From: [REDACTED]
Sent: 17 September 2024 12:47
To: Planning
Subject: Application Number: 3/2024/0645

Re planning application: 3/2024/0645

PL.03

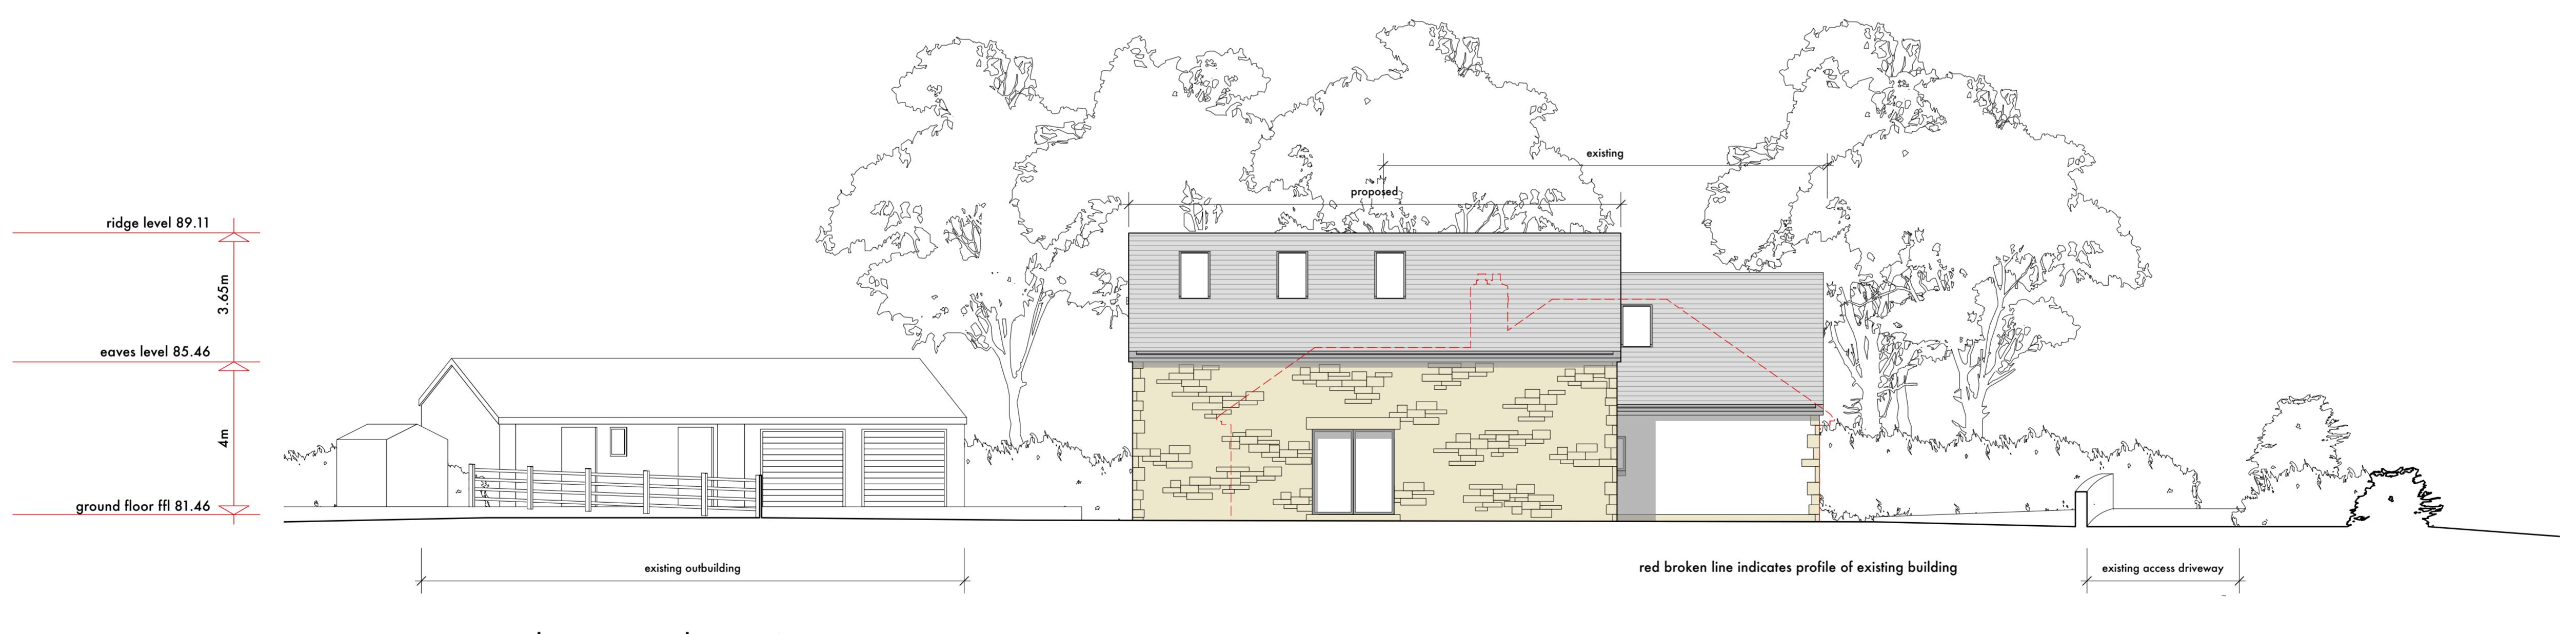
With regards to the above planning application. We have great concerns regarding the proposed plans for North West elevation of the property.

The proposed upper floor windows on the North West elevation will be detrimental to [REDACTED] [REDACTED] Preston Road or surrounding area. The inclusion of the proposed windows is of suburban character which would be unsympathetic to the rural surroundings, appearance and visual amenities of the area.
